Proposal: Application for approval of details reserved by condition imposed under BR/54/16/PL relating to condition No. 7 (Construction management plan), 10 (Surface water drainage), 12 (Watercourse), 14 (External lighting scheme), 15 (Noise), 16 (Public sewers), 17 (Foul & surface water sewerage disposal), 18 (Cars), 19 (Roof plant), 23 (Landscaping scheme), 24 (Tree retention & protection plan), 25 (Programme of archaeological work & scheme of investigation), 26 (schedule of materials) & 34 (Programme of ecological work)

Site: University of Chichester, Upper Bognor Road, Bognor Regis, PO21 1HR.
BR/214/16/DOC

Southern Water cannot recommend discharge of condition 10, 16 and 17 relating to foul and surface water drainage.

S185 DEVELOPER DIVERSION PROPOSALS

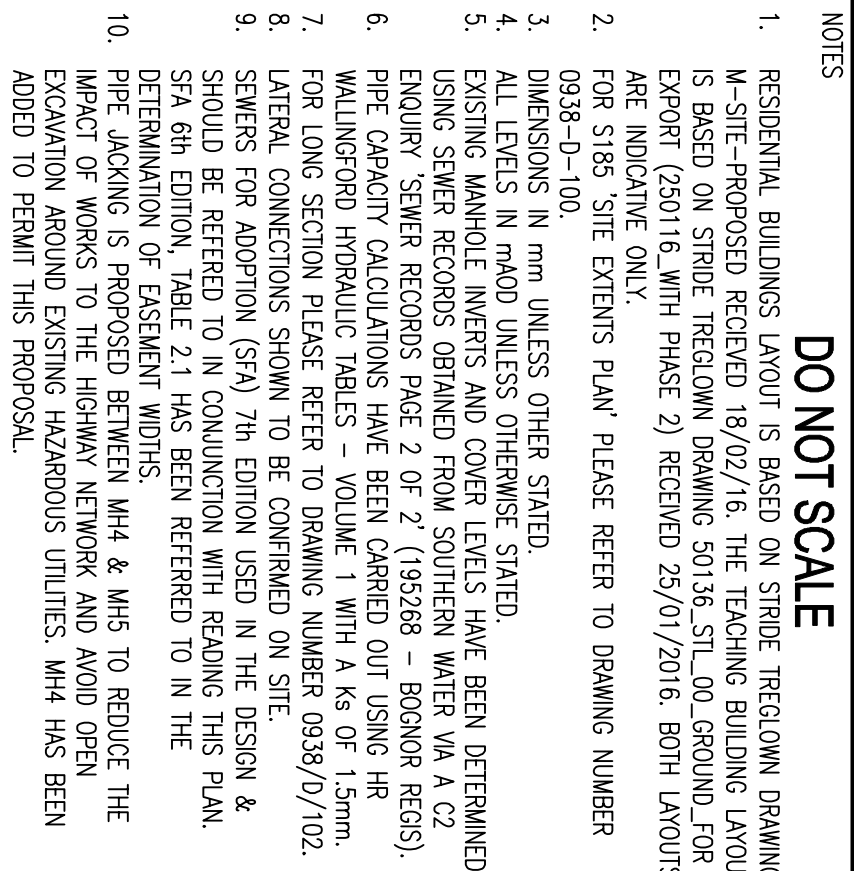
The public sewer diversion proposals should be agreed and approved by Southern Water under Section 185 of the Water Industry Act before the condition relating to protection/ diversion of public sewers can be discharged.

TITLE: PRELIMINARY STORMWATER DRAINAGE FOR COORDINATION

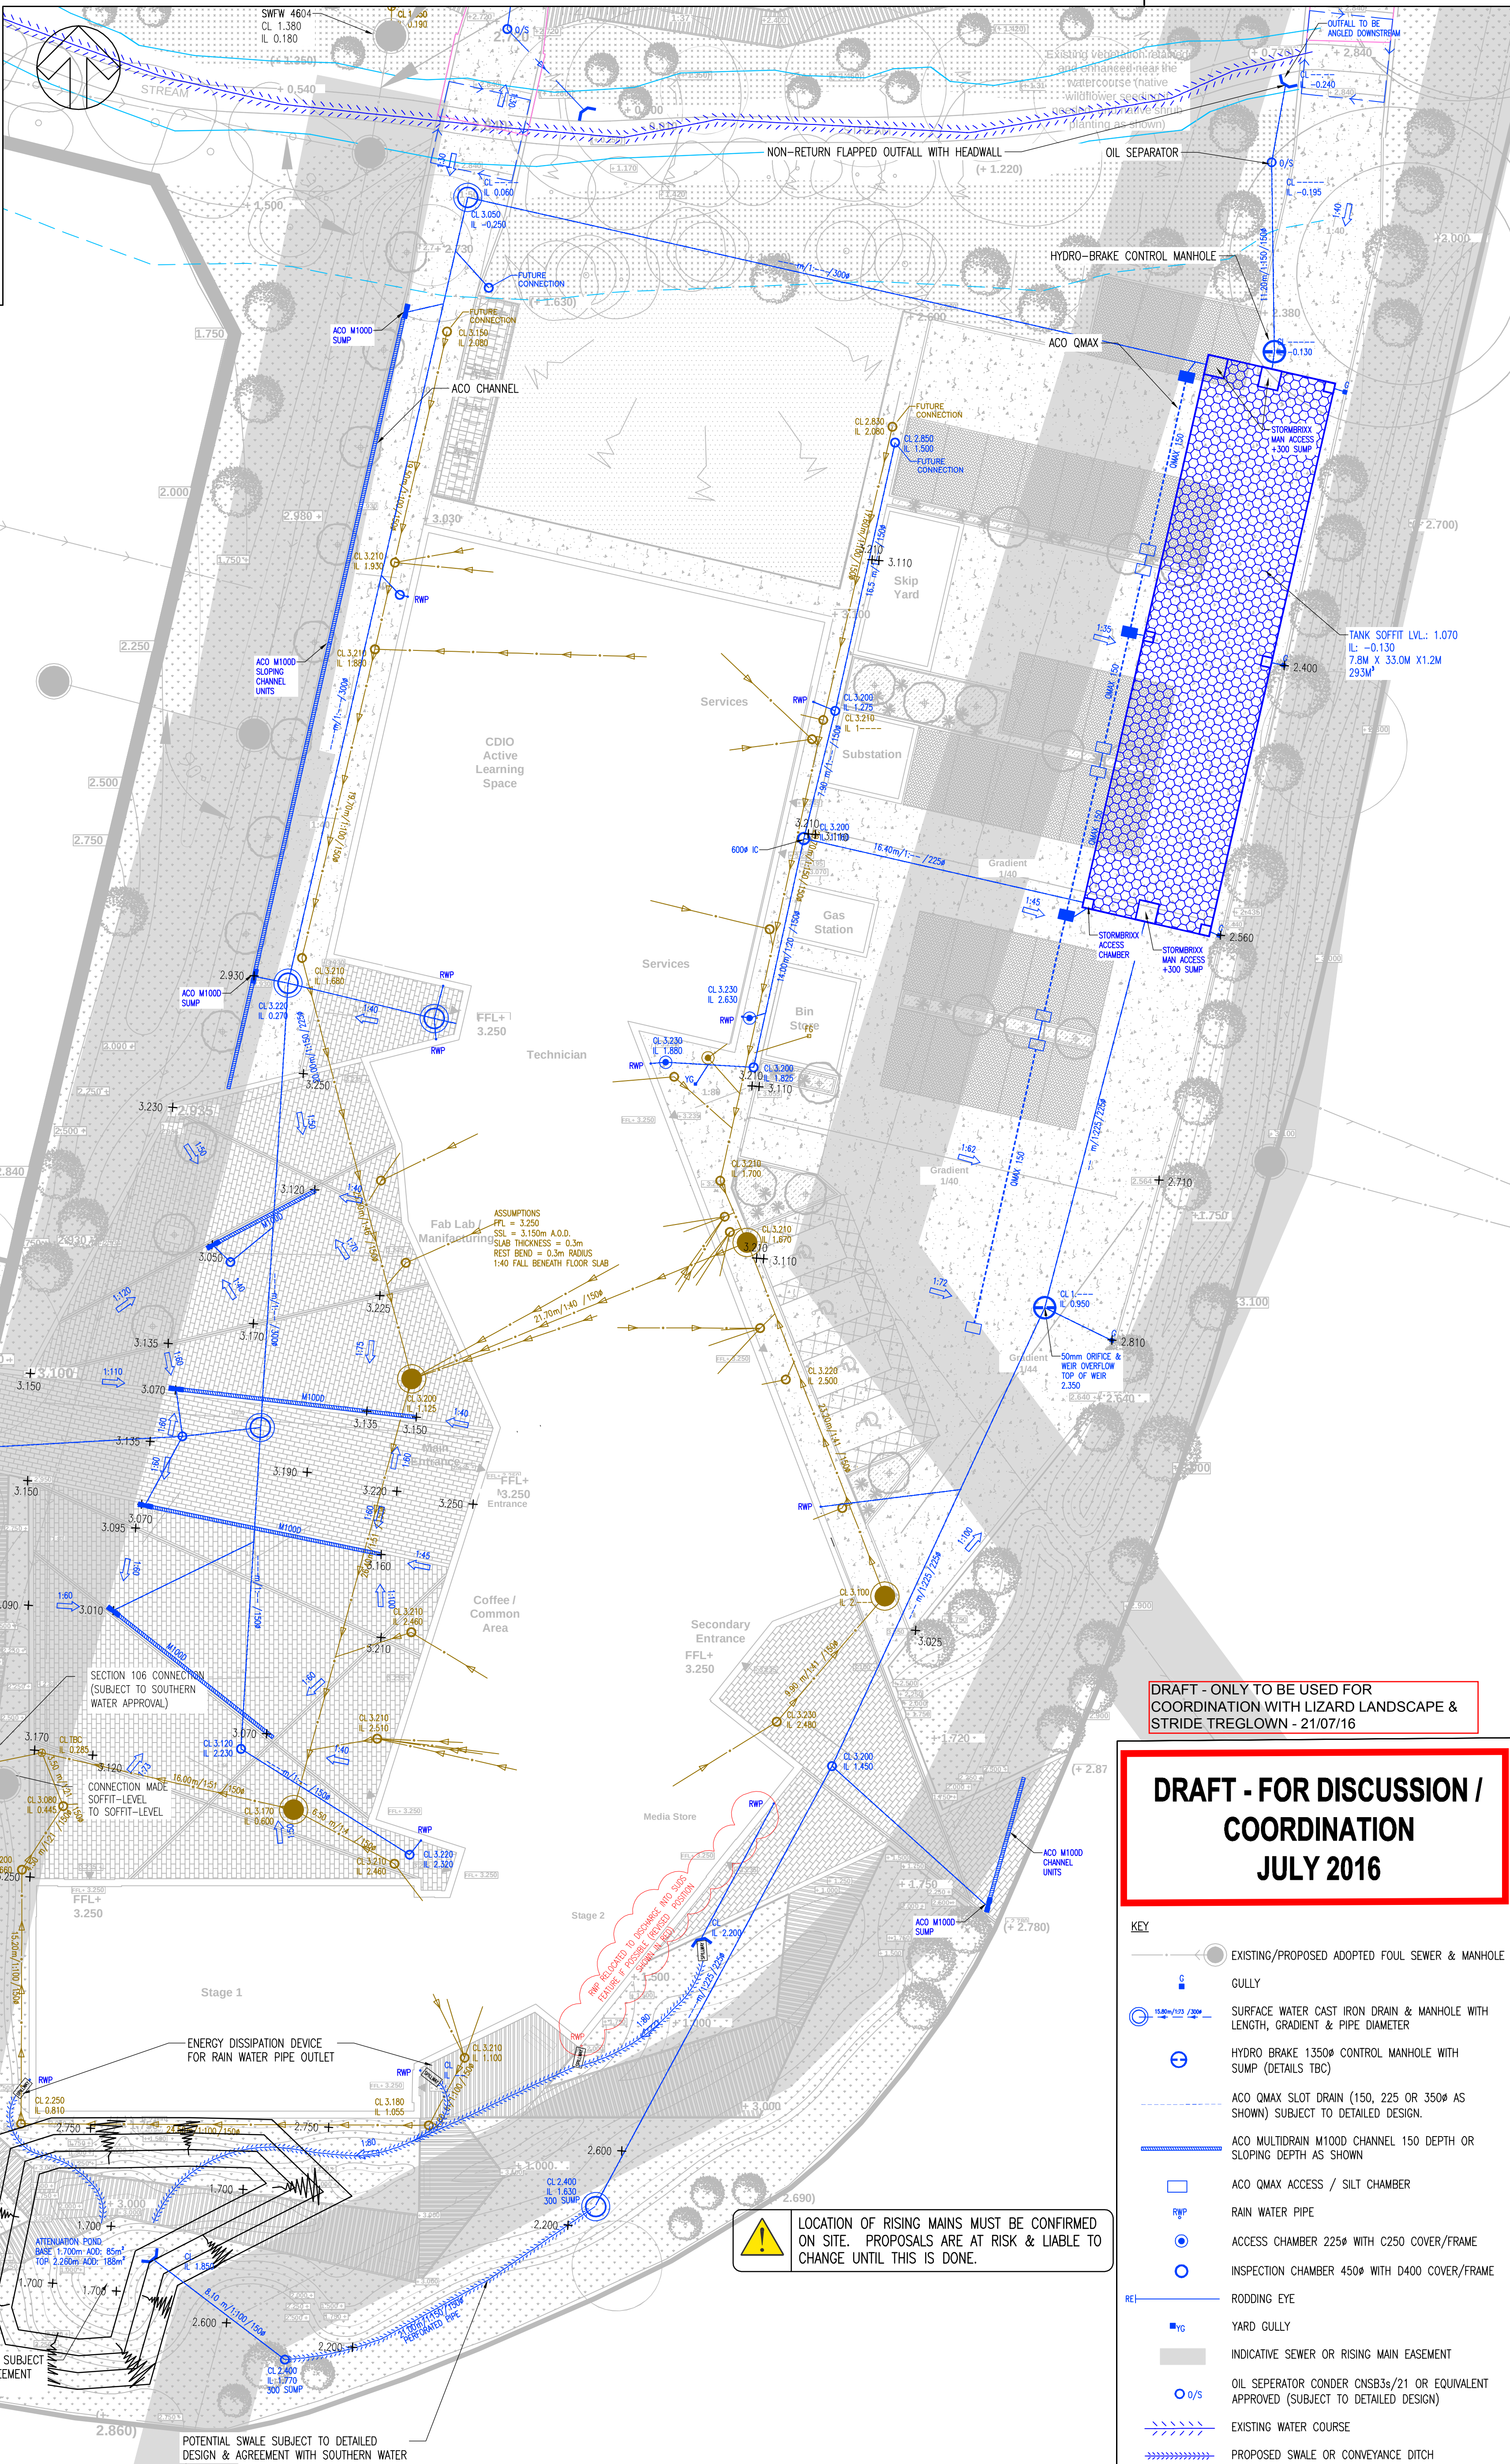
Construction of permeable paving over or within clearance distance of public or adoptable sewers will not be acceptable.

No new ponds, swales or other water conveying or retaining features should be located within 5 metres of the public or adoptable sewers.

The proposed on site foul and surface water drainage is not adoptable by Southern Water.
